CITY OF ALBUQUERQUE

Re: Holiday Bowl
7515 Lomas NE
Traffic Circulation Layout
Engineer's Stamp **04-16-18** (J19-D082A)

Based upon the information provided in your submittal received 04-23-18, the above referenced plan cannot be approved for Building Permit until the following comments are addressed:

TRAFFIC CIRCULATION LAYOUT
APPROVED

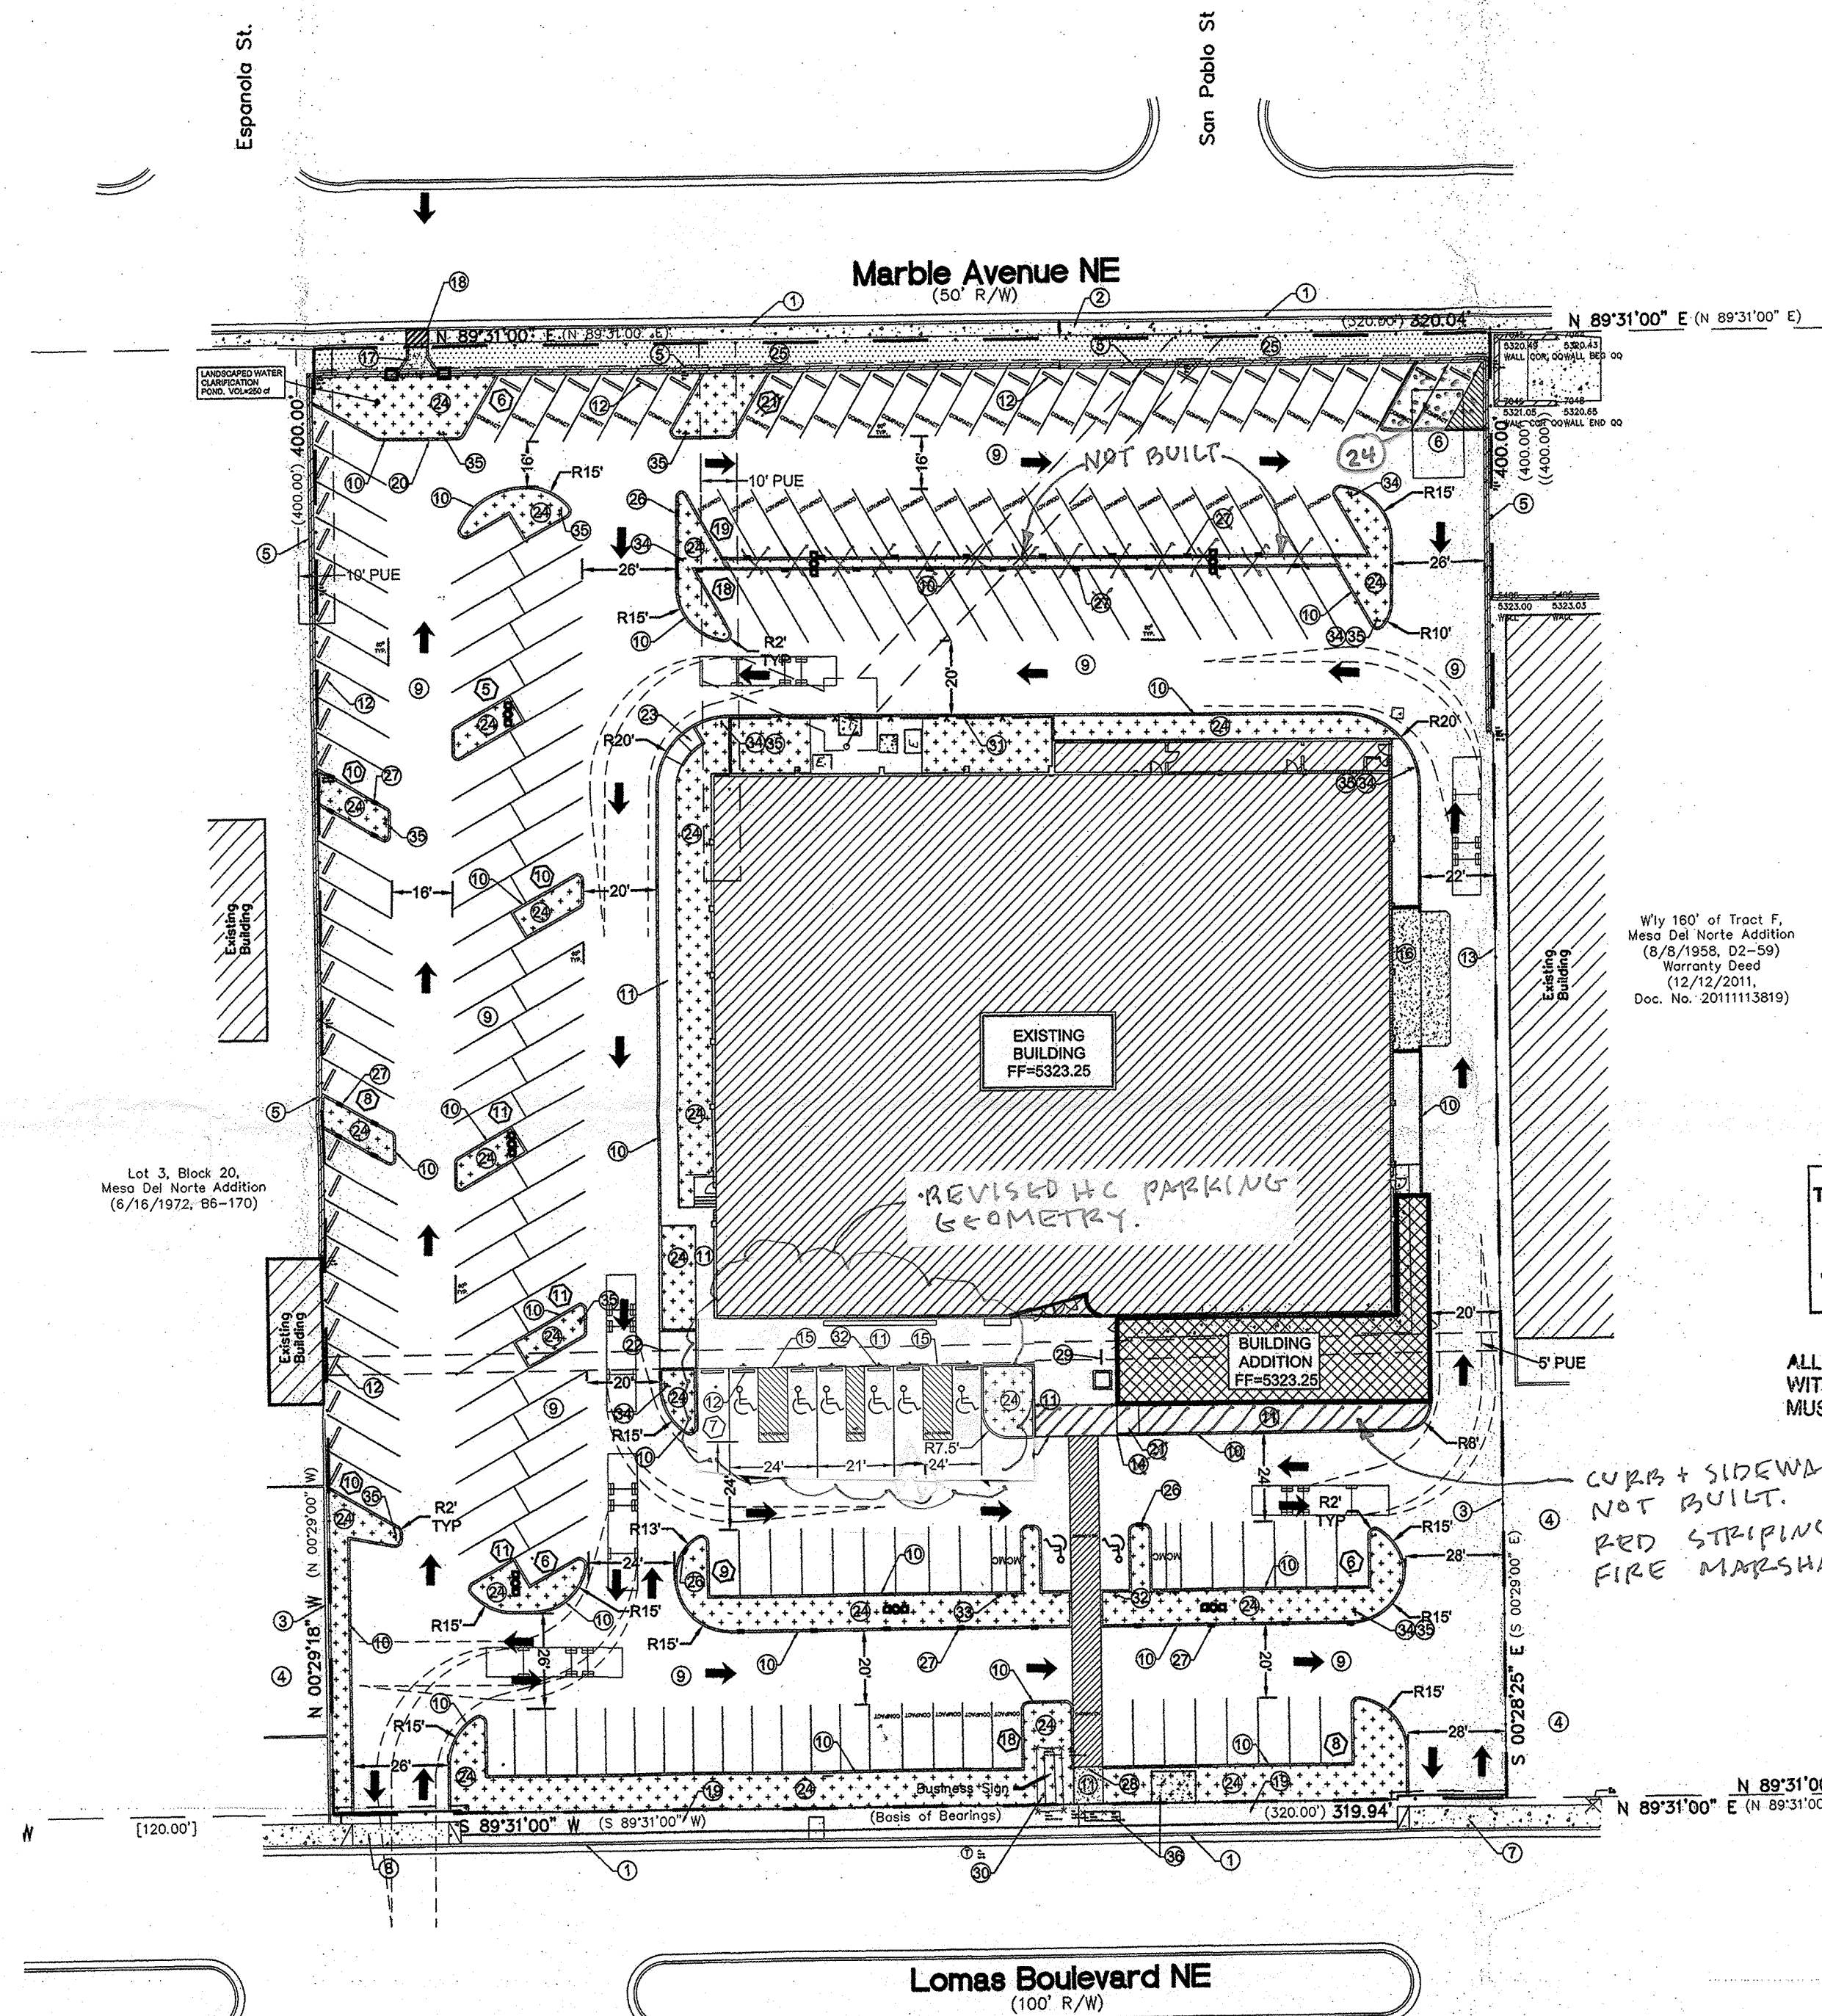
1. Service vehicle and/or refuse vehicle maneuvering must be contained on-site; provide a copy of refuse approval. Show location of refuse container.
2. One-way vehicular paths require pavement directional signage and a posted **"Do Not Enter"** sign at the point of egress. Please show detail and location of posted signs. This is for all one-way aisles, any aisle less than 24 feet with
